**City of Albuquerque, NM  
Plan Review**

**RE: Building Plan Check Corrections  
BP-2024-40415  
TA Travel Centers #081  
2501 University Blvd, NE  
Albuquerque, NM 87107**

TA Travel Centers received the following comments regarding the proposed installation of an automated parking gate. The individual comments and replies are provided below.

E1.0

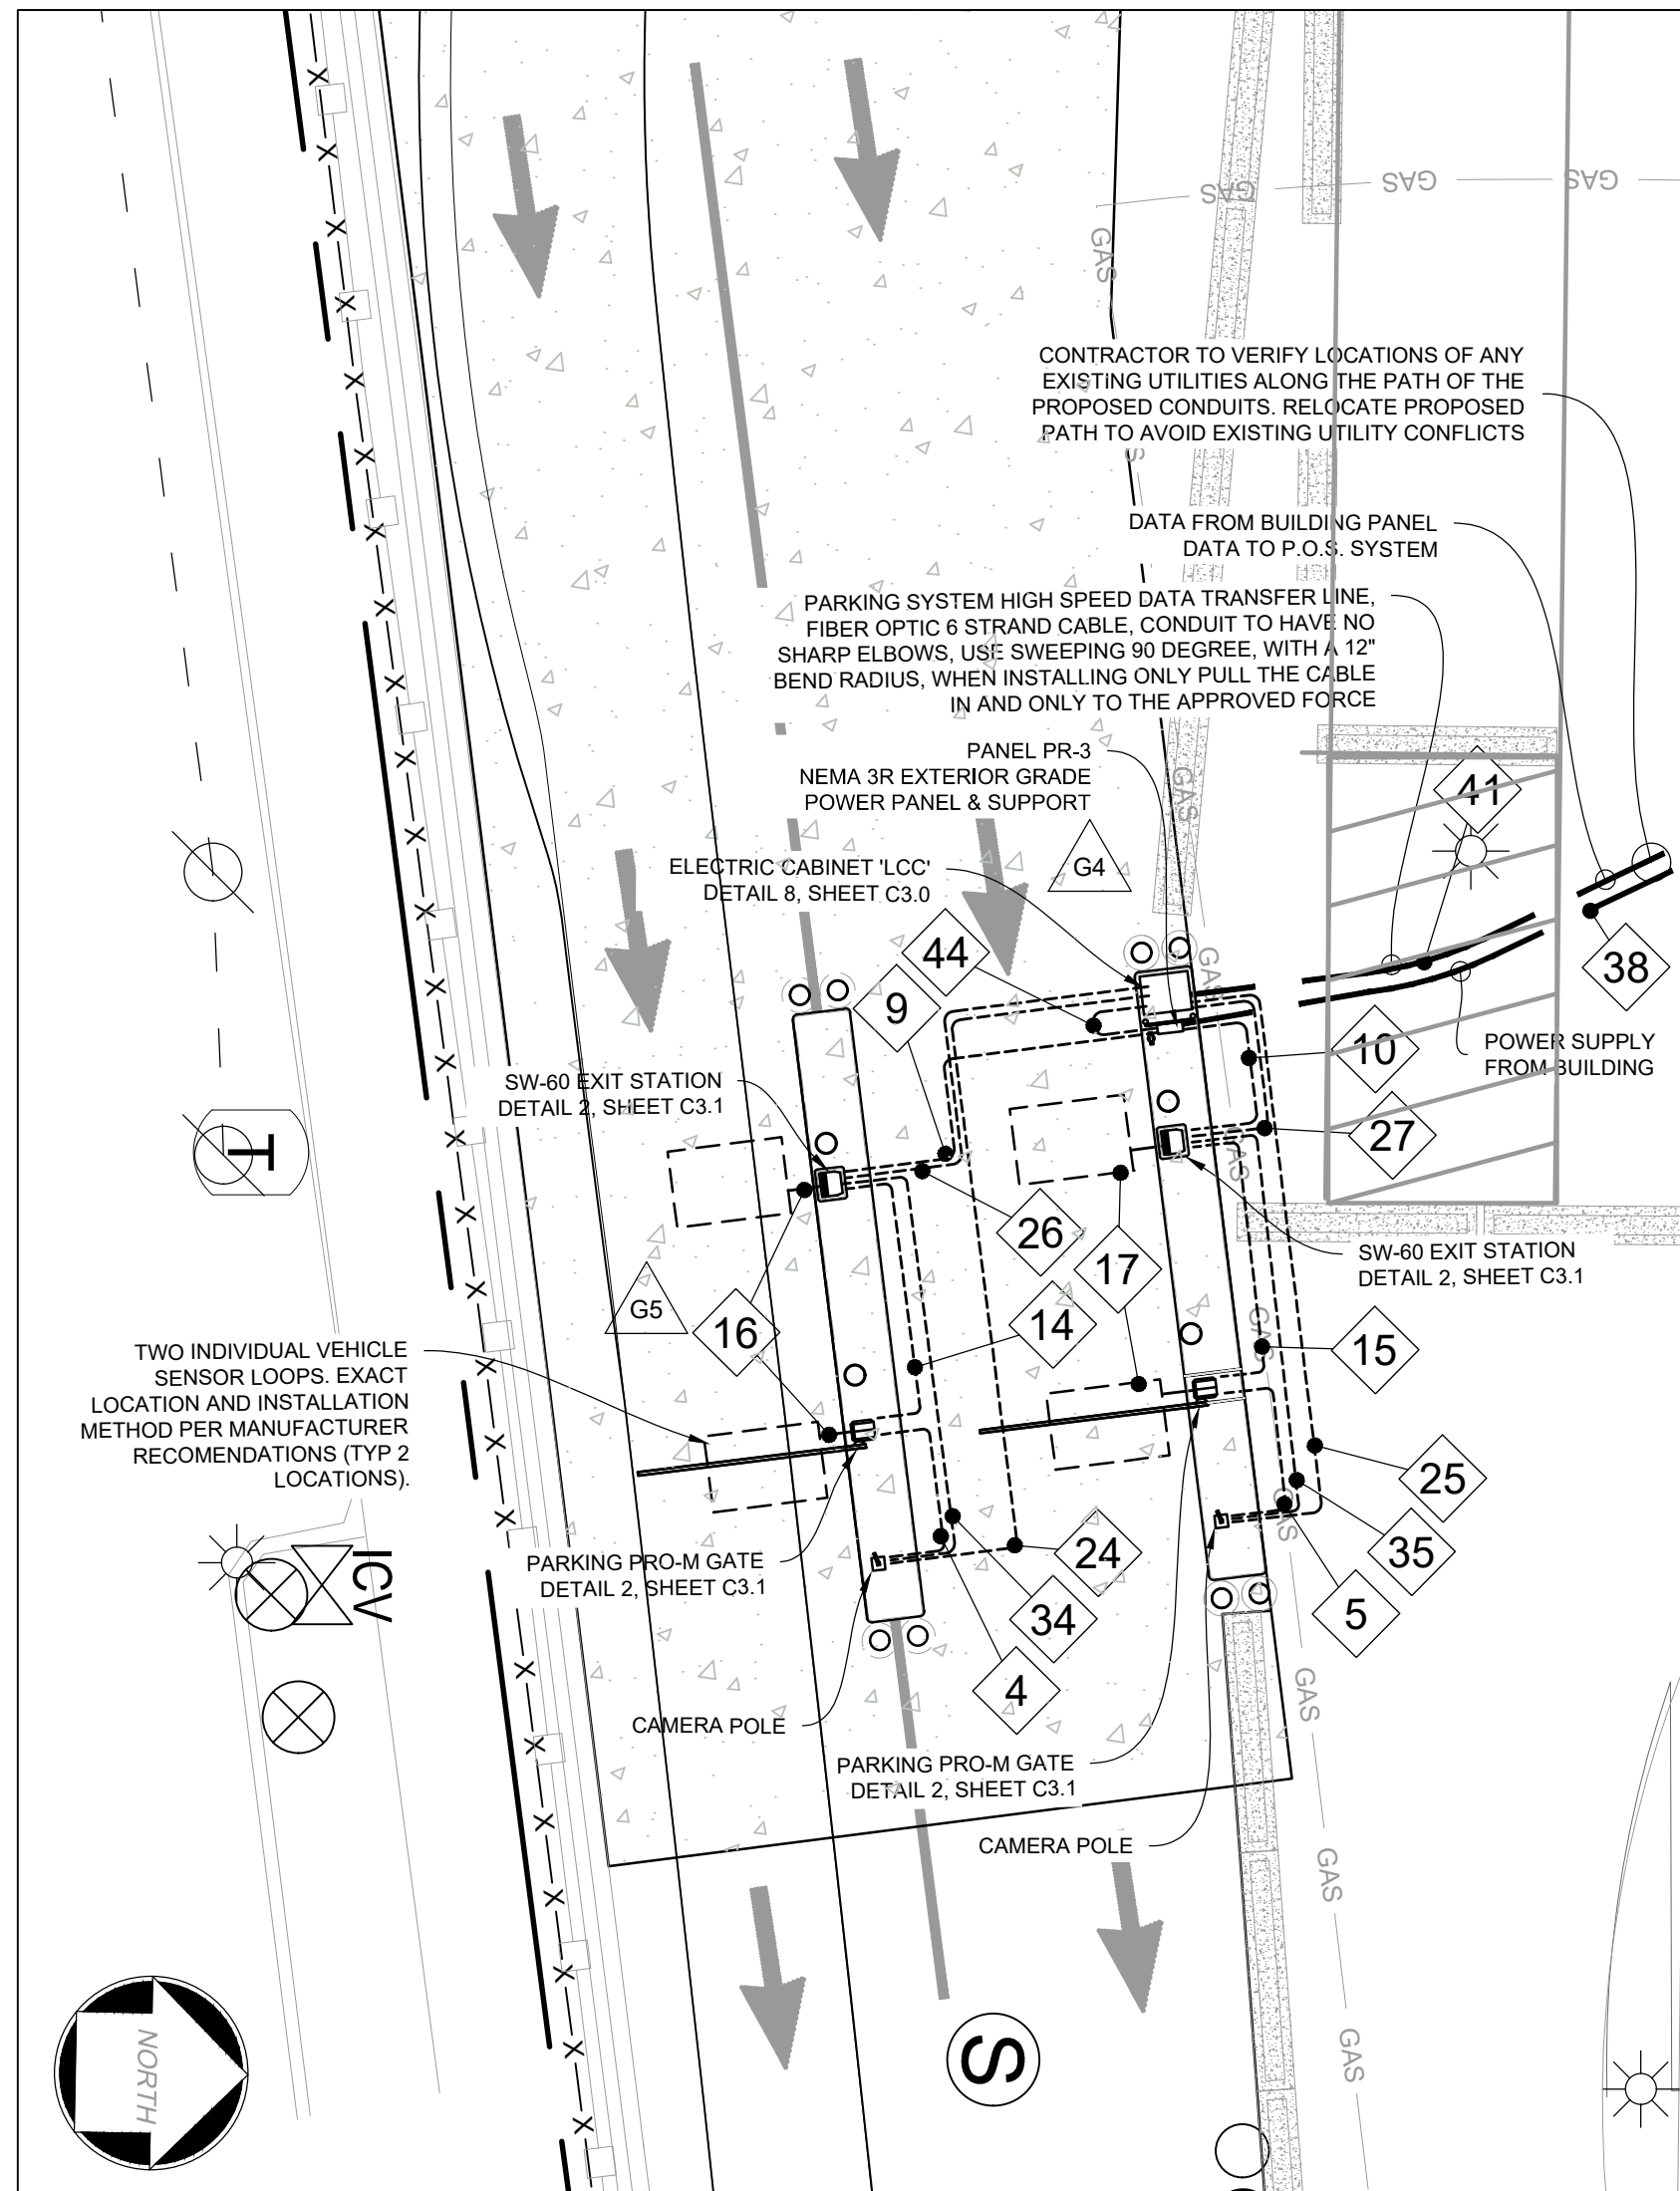
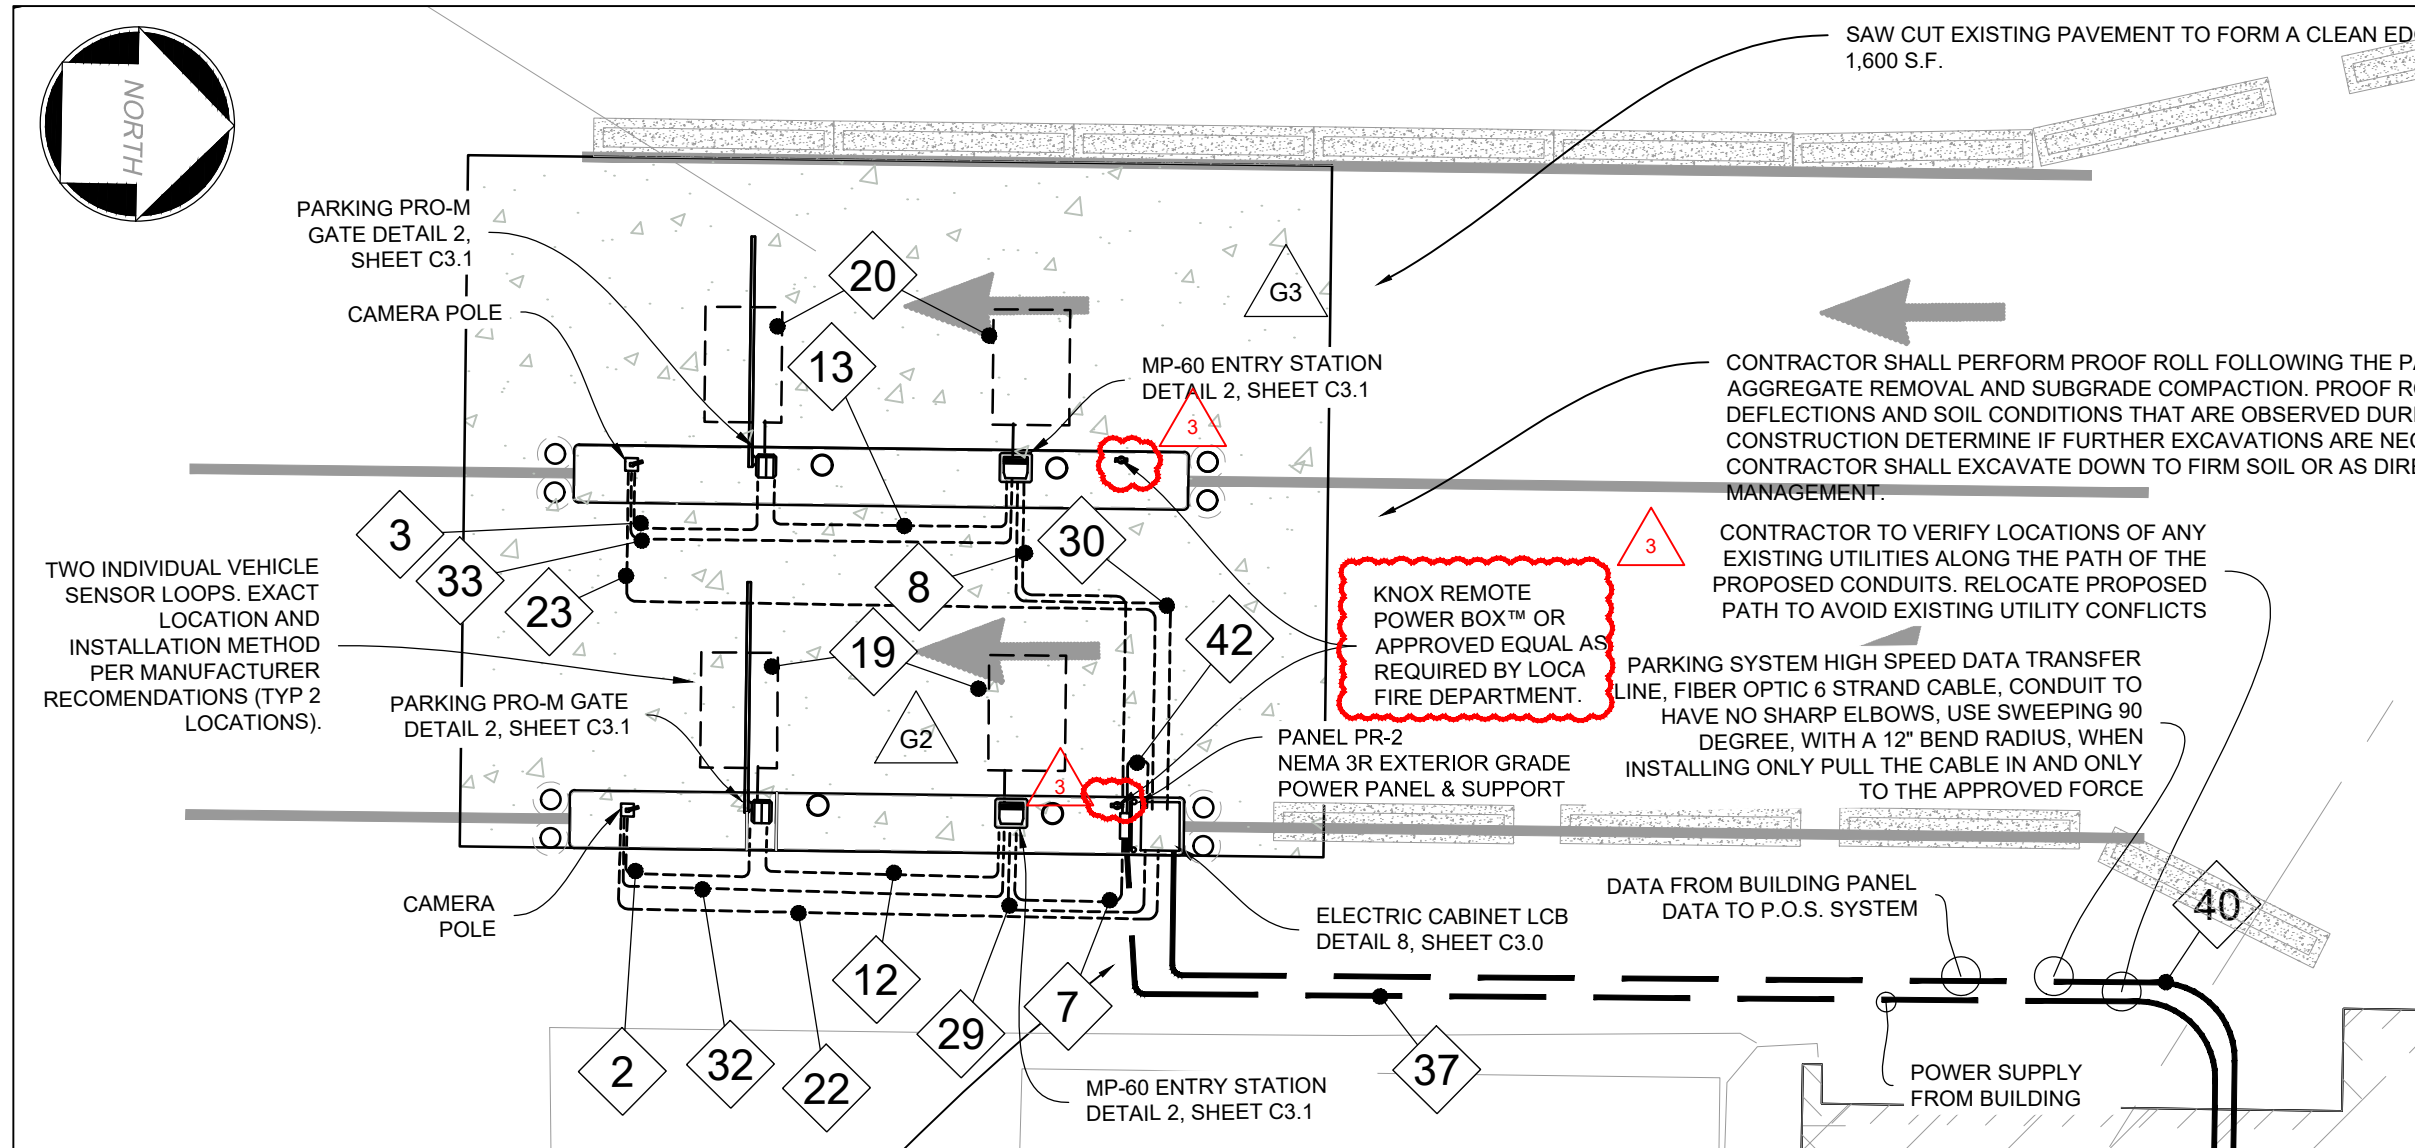
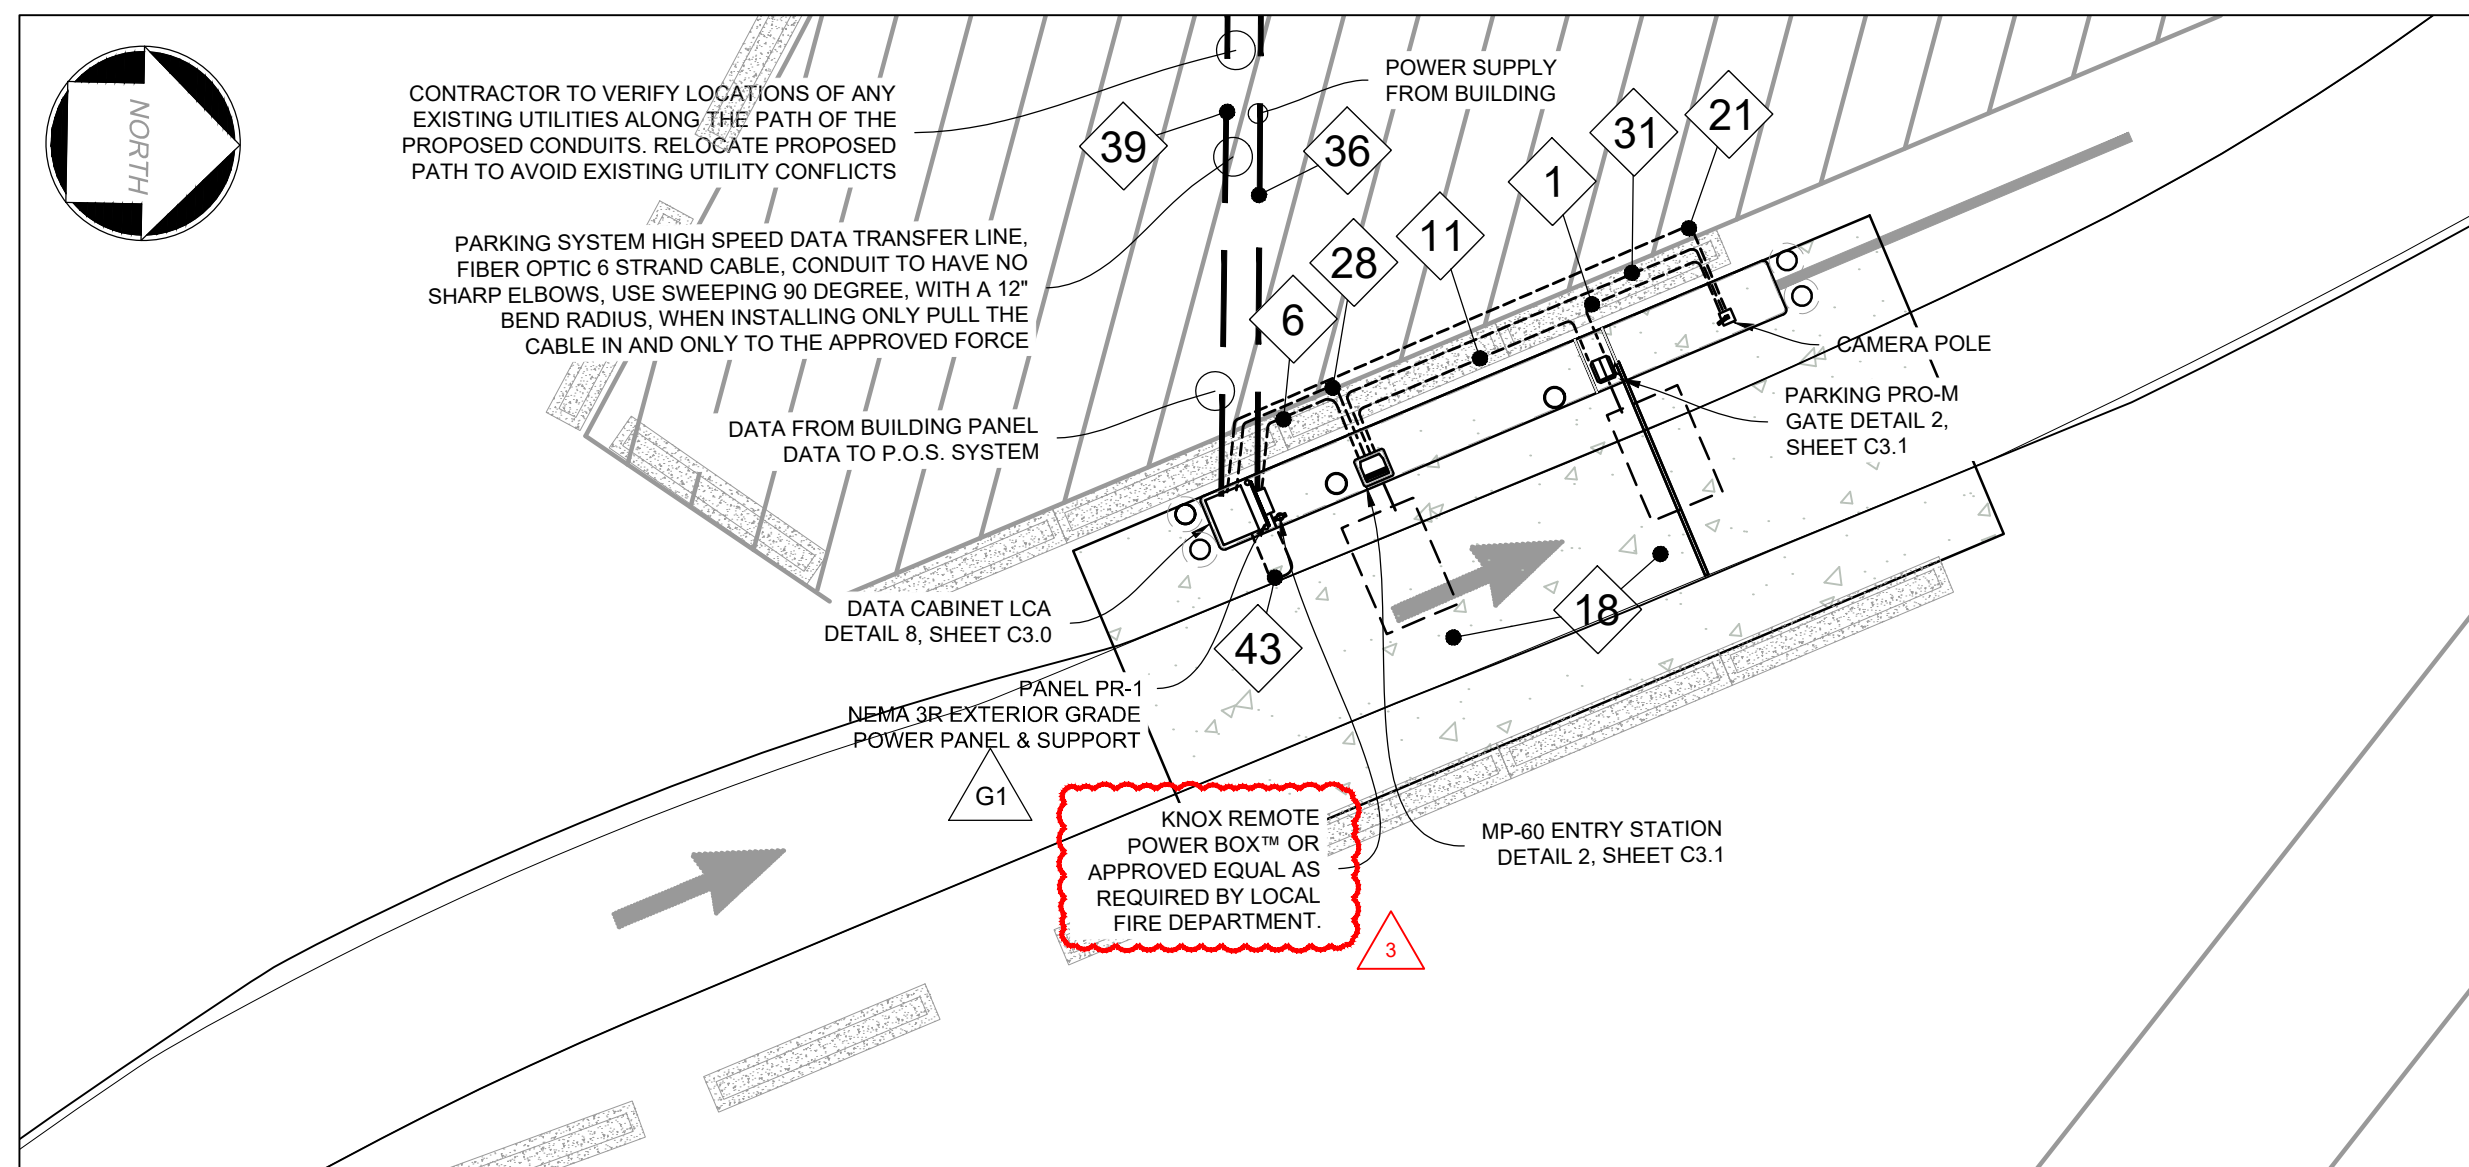
\*AFR WOULD LIKE COMPLETE ACCESS FOR APPARATUS. GATE DETAIL LARGE ENOUGH FOR LADDER ACCESS? KNOX KEY SWITCH ON GATES? EXIT DISCHARGE IN BUBBLED ARE NOT COMPLETE, WHERE DOES THIS EXIT LEAD, I.E. MAJOR ROADS.

1) Drawing E-1.0. E-1.1, E1.2, E-1.3 > all Panels > Indicate the UL listed AIC rating of the panel per 2020 NEC Â§ 110.3.

Comment: 2) Drawing E-1.0. E-1.1, E1.2, E-1.3 > Provide fault current calculation per 2020 NEC § 110.24.

- Please find the attached Drawing PDF titled “#081 Parking Gate-TT1.0 Truck Turn Plan” and “#081 Parking Gate-E1.0 Conduit Plan” showing installation location of Knox box. addressing comments item Ref.#4. Access gates lanes are 14’6” wide allowing emergency vehicle access.
-

- Please find the attached Drawing PDFs titled “#081 Parking Gate-E1.0 Conduit Plan”, “#081 Parking Gate-E1.1 Electrical Details”, “#081 Parking Gate-E1.2 Electrical Details” and “#081 Parking Gate-E1.3 Electrical Details” addressing comments item Ref.#5.
-

- Upon review of comments between Jason Gomke of Wellert and Mr. David Tedford, the requirement for ground fault current calculations does not apply to this scope of work.
-
